**Recommendation Report for Listed Building Consent for Alterations, Extension or Demolition of a
Listed Building**

REF NO: BR/137/21/L

LOCATION: Berghestede
1 Shripney Road
Bognor Regis
PO22 9LW

PROPOSAL: Listed building consent for replacement of existing non-original sash windows with retention of existing frames.

Drawing Number:
PO22 PR1

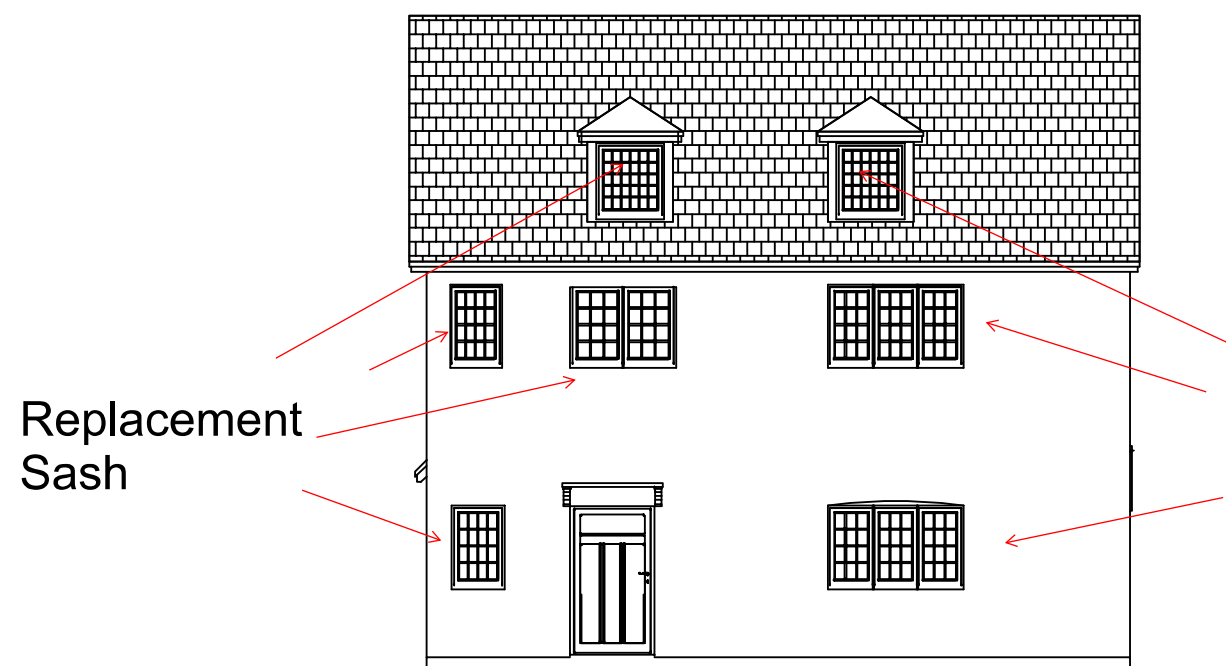
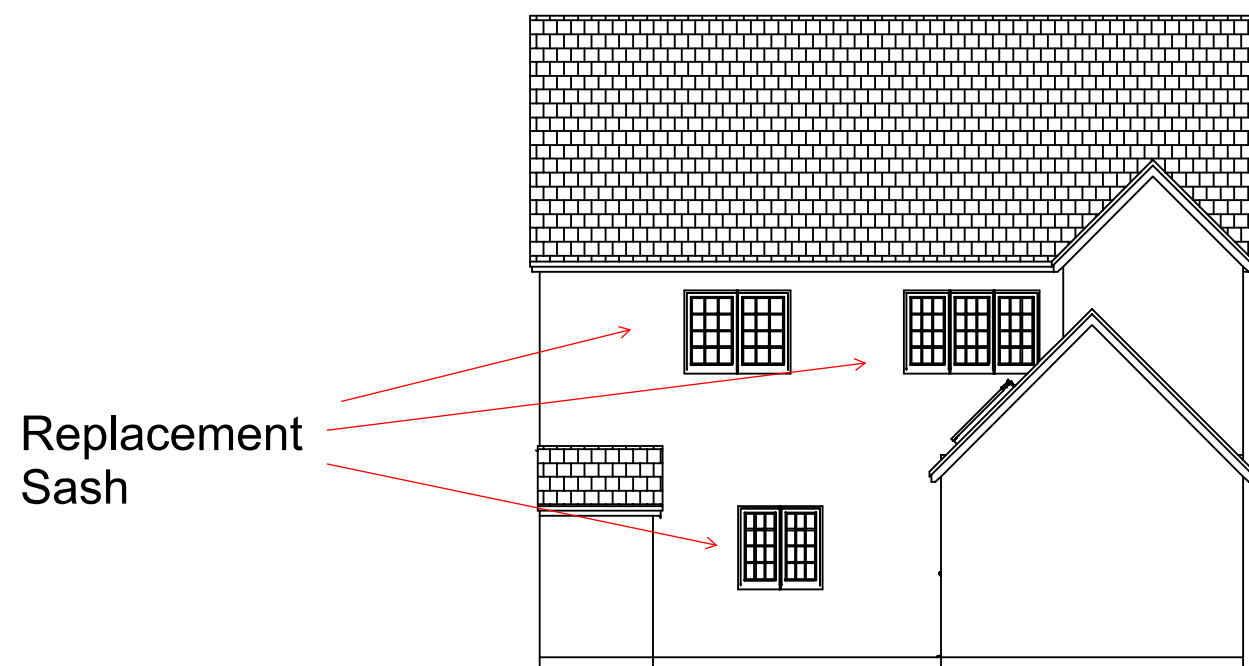
The information provided does not contain sufficient detail with regards to the glazing system proposed or the dimensions. Full elevation details are not provided and it is not clear what the appearance would be. It is also difficult to tell how any glazing bars, if any, will be treated.

The use of standard double-glazed units will not only increase the perception of modern, standard windows, but also affect the design of the windows themselves. This would harm the character and appearance of the listed building. This type of double glazed unit and window design is not appropriate for a listed building and is considered to cause harm.

Following comments from the Conservation Officer, there is concern as to the lack of assessment of alternative options to improve their thermal efficiency. Further, the windows are a key element of this particular house and the use of the double glazing is of concern.
